Our Ref: JAH/SH

Application ref: P/12/15/PL

Land to the east of 29 Harbour Front Road, Pagham

Proposed erection of 3 detached bungalows, each with garage, parking and deck

Ground Floor Plan

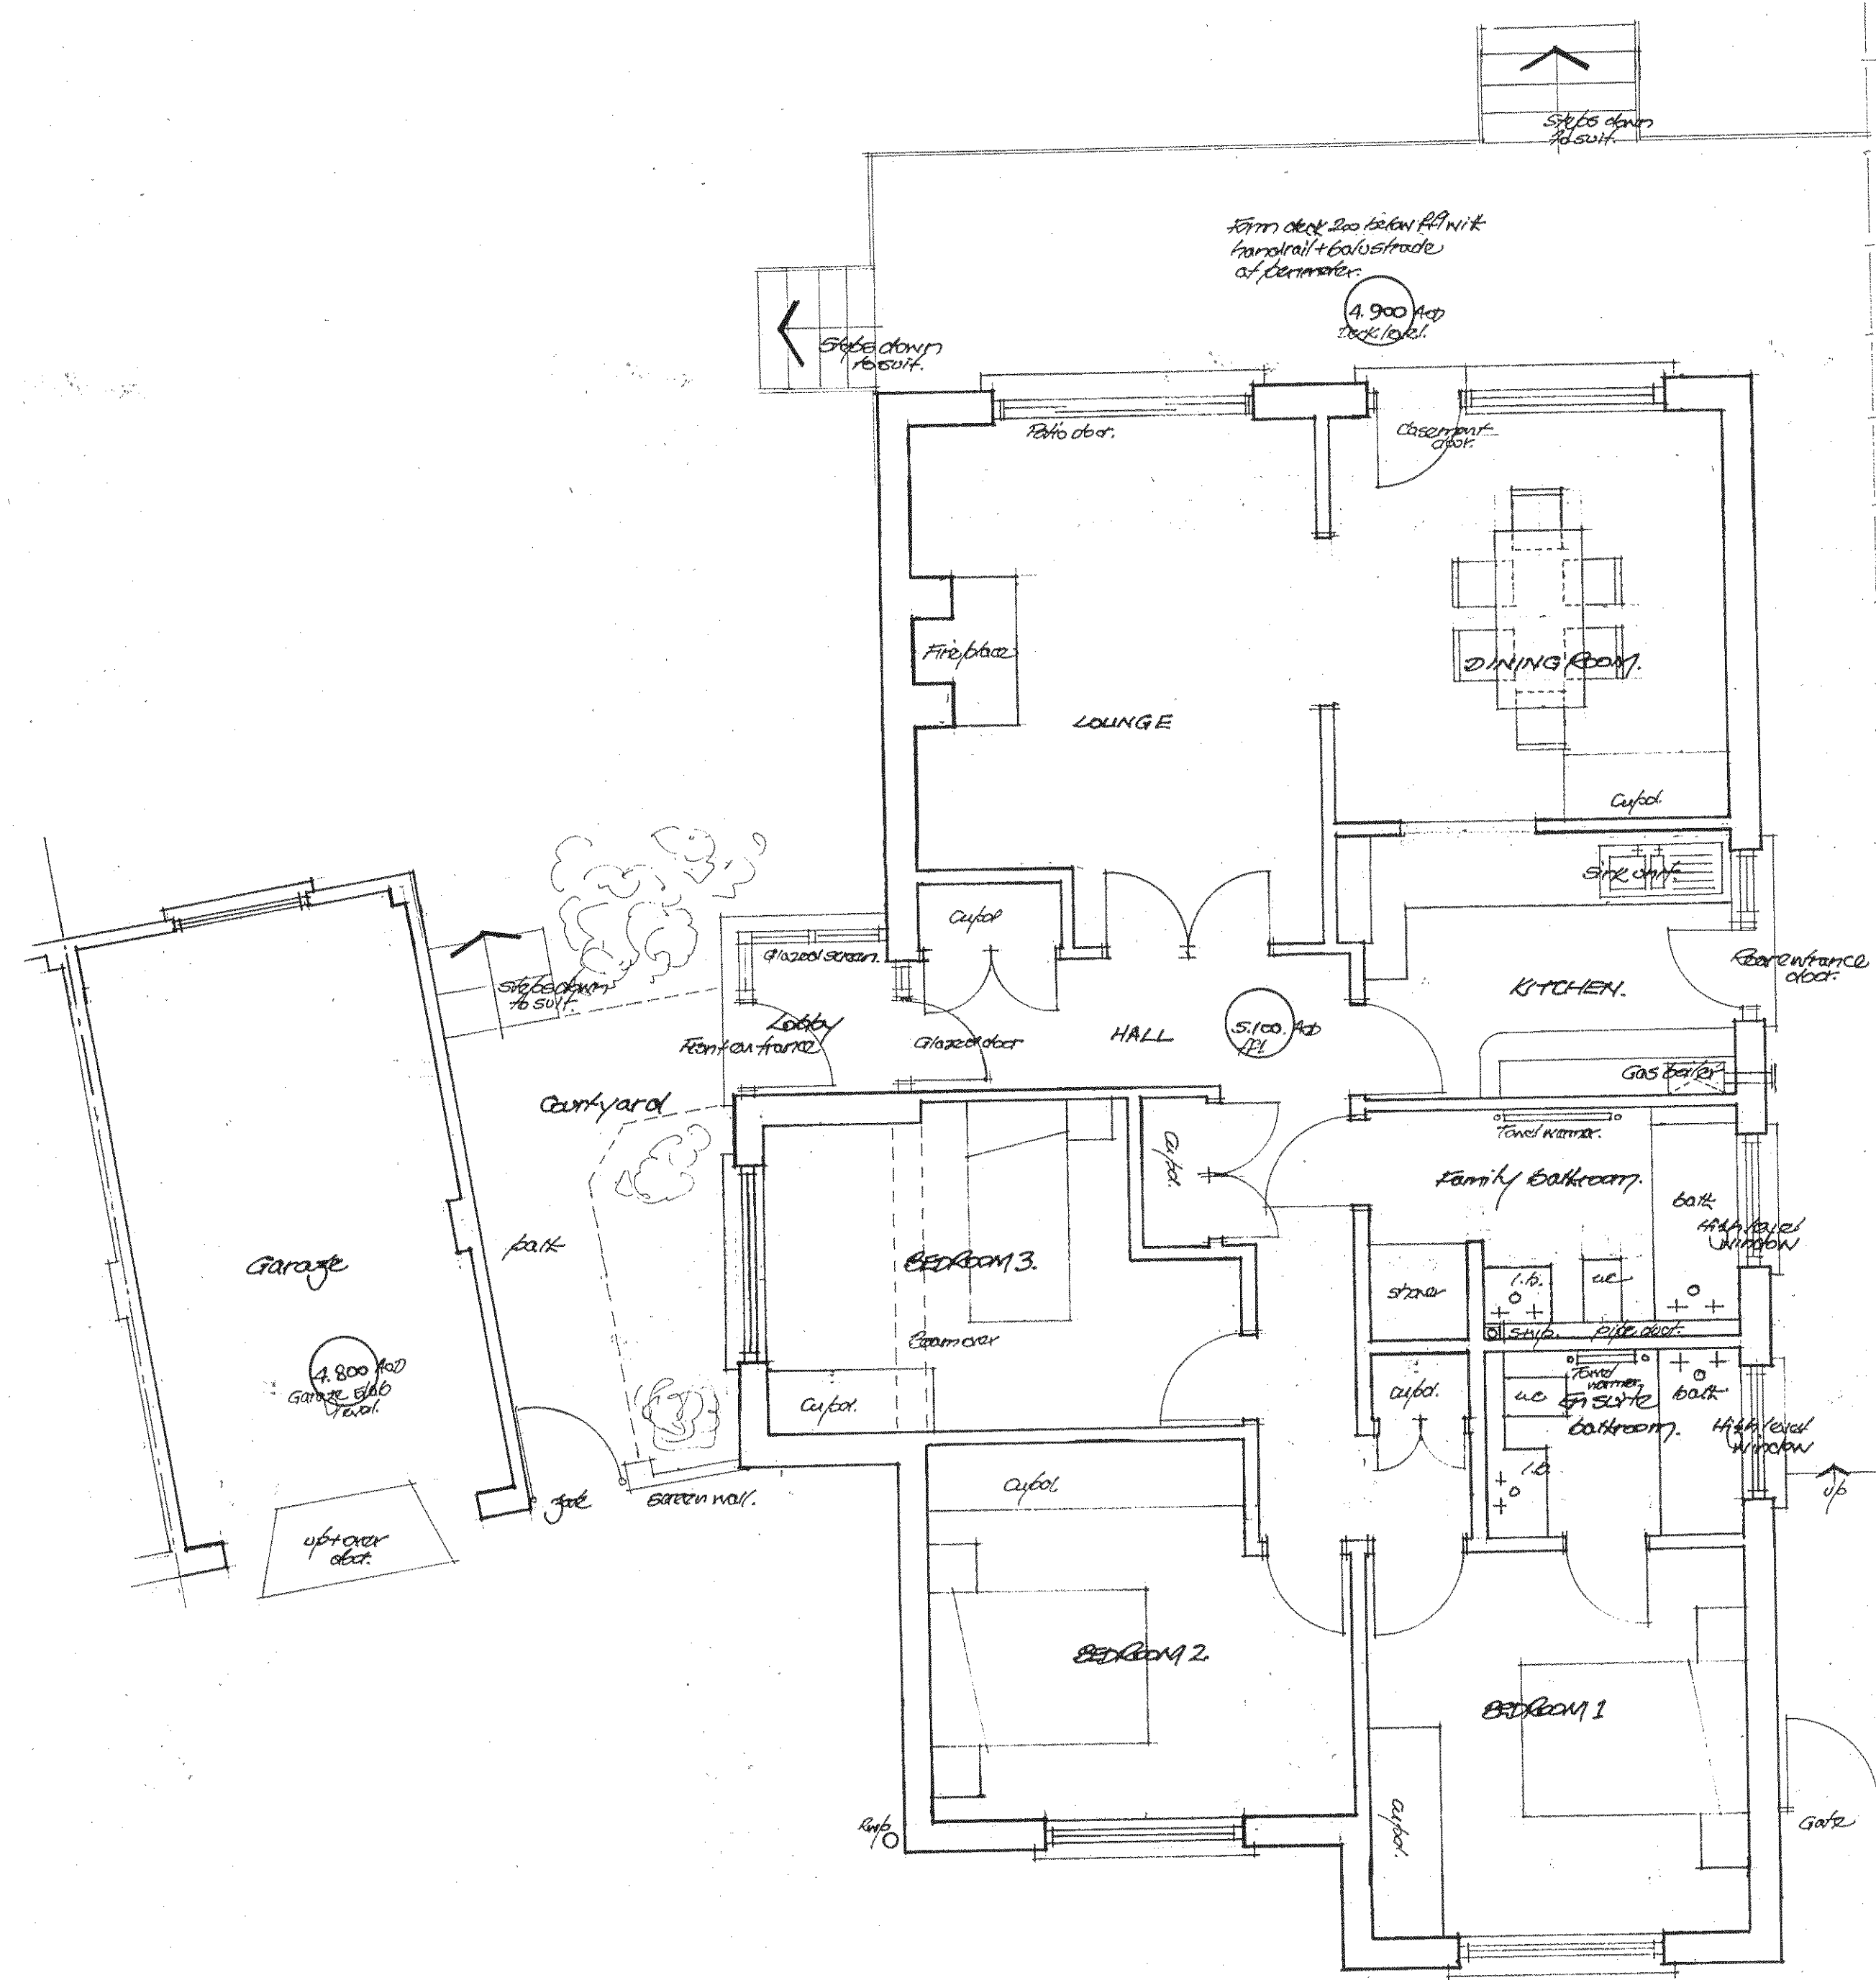
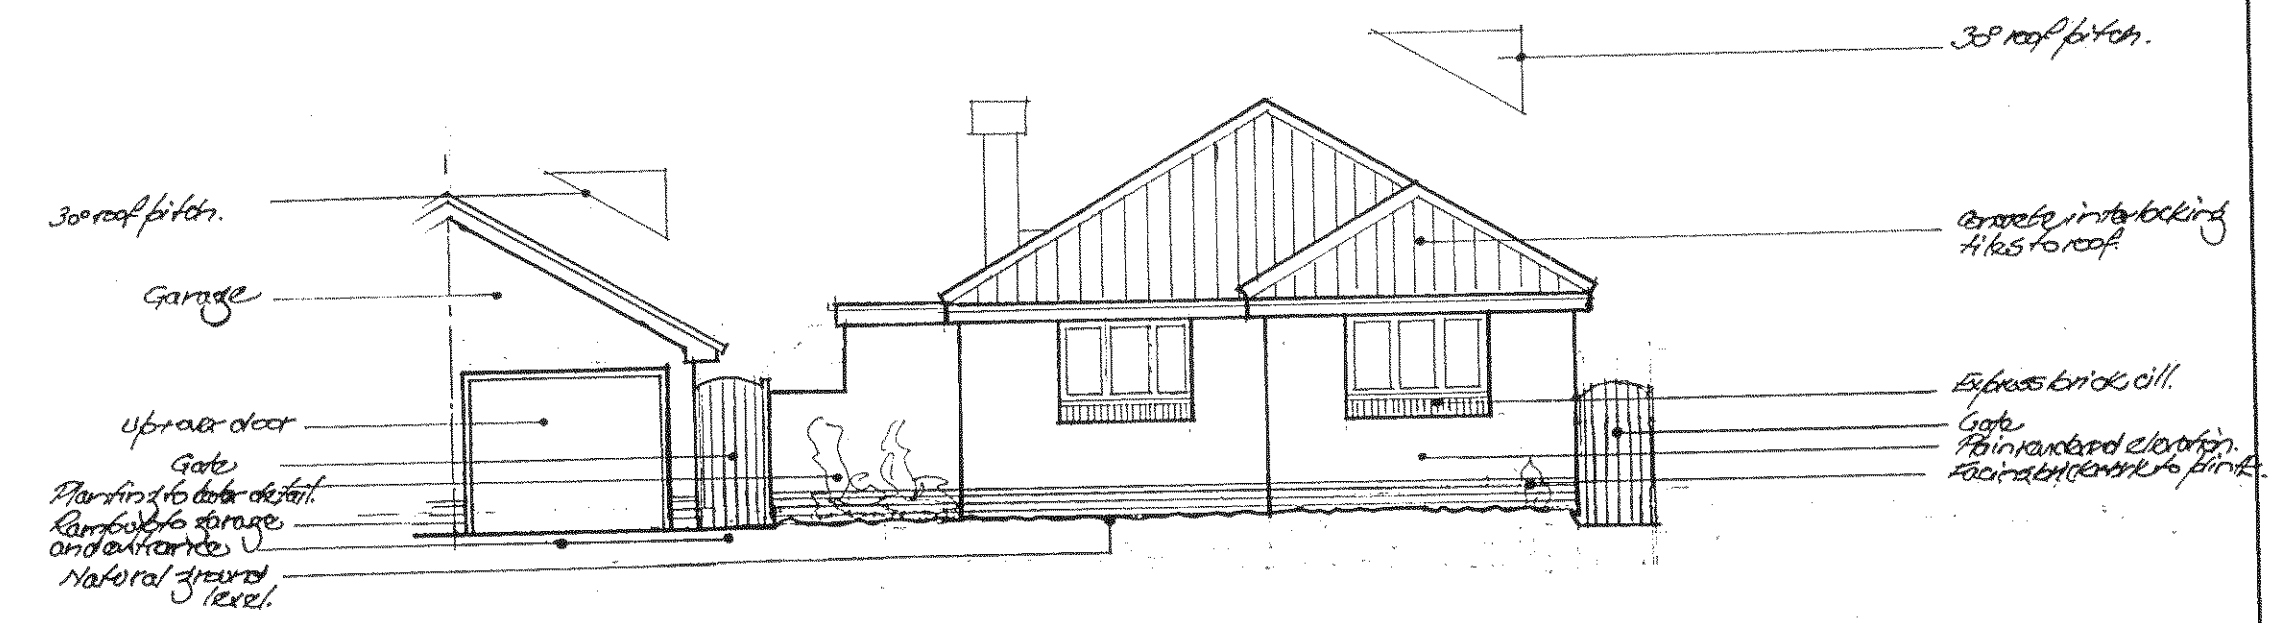
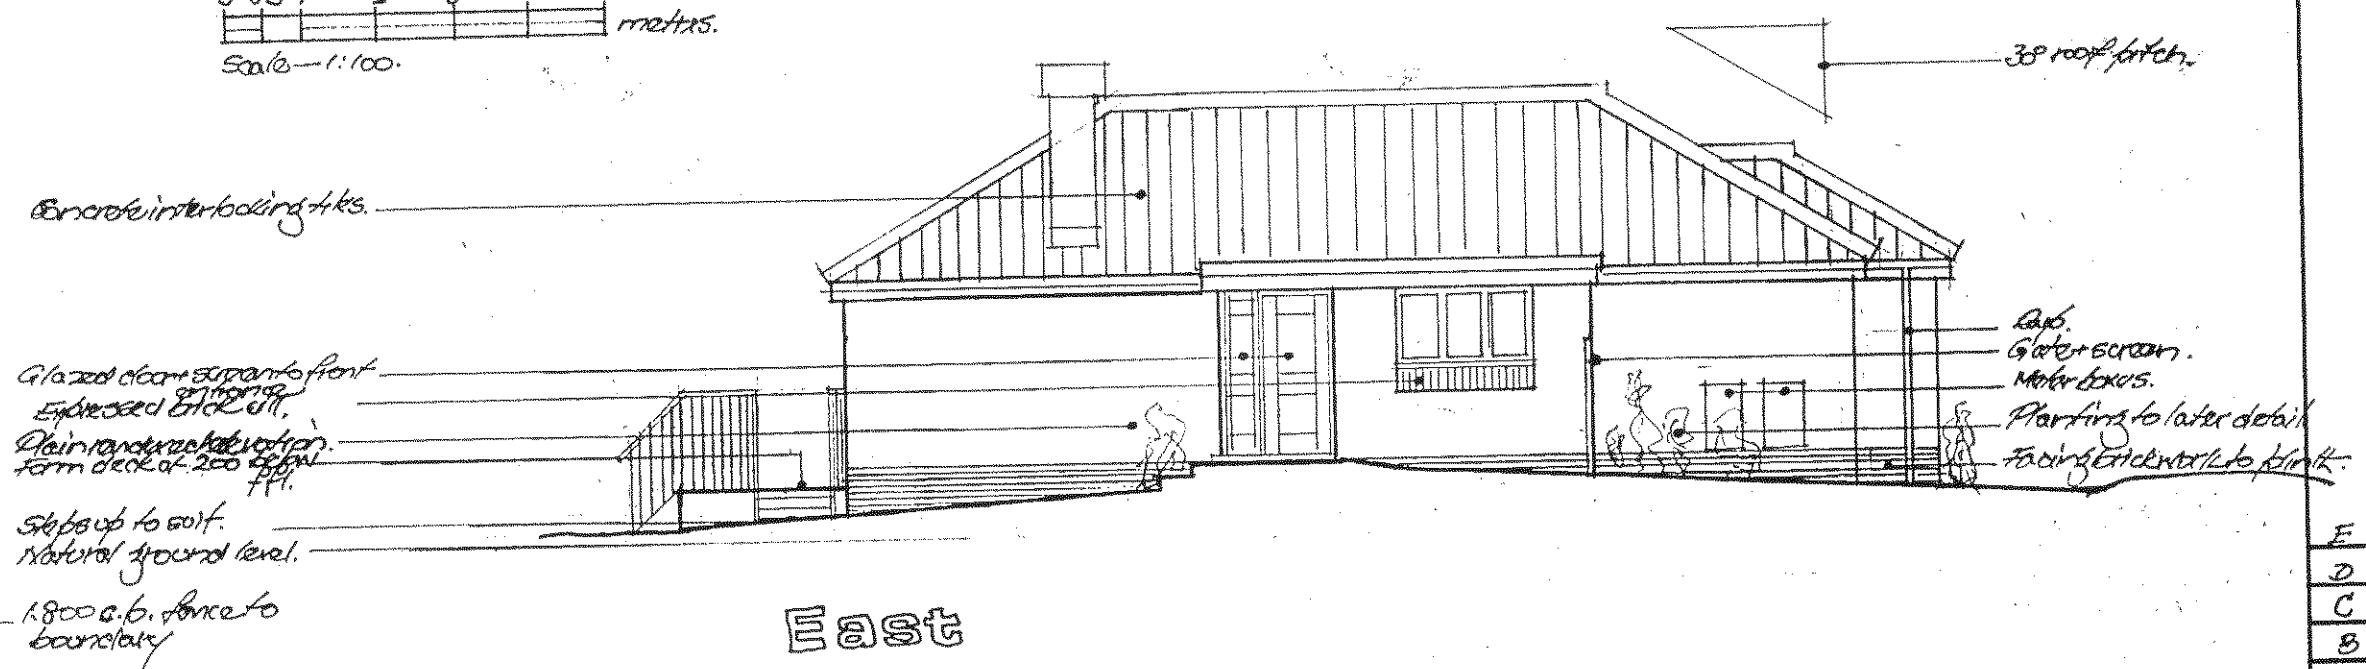
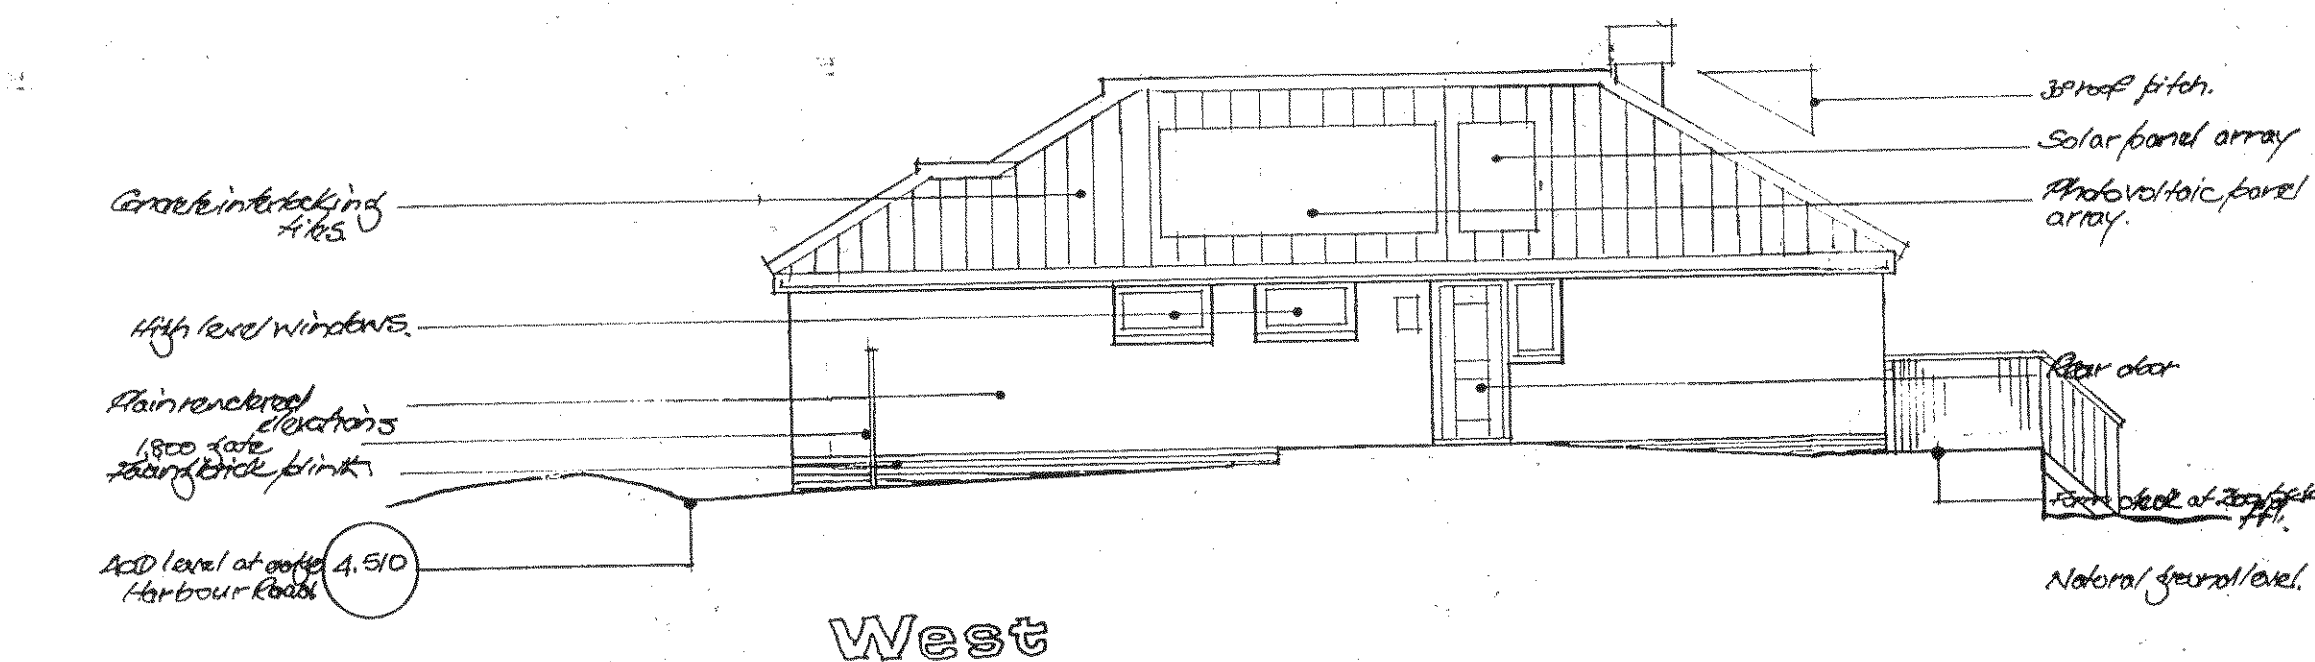
This change in finished floor levels and the AOD levels have also enabled the scheme to be amended and I therefore enclose for your attention two sets of Drawings no. 05/109/04E, 05E and 06E, which show the proposed bungalows with the revised AOD levels.
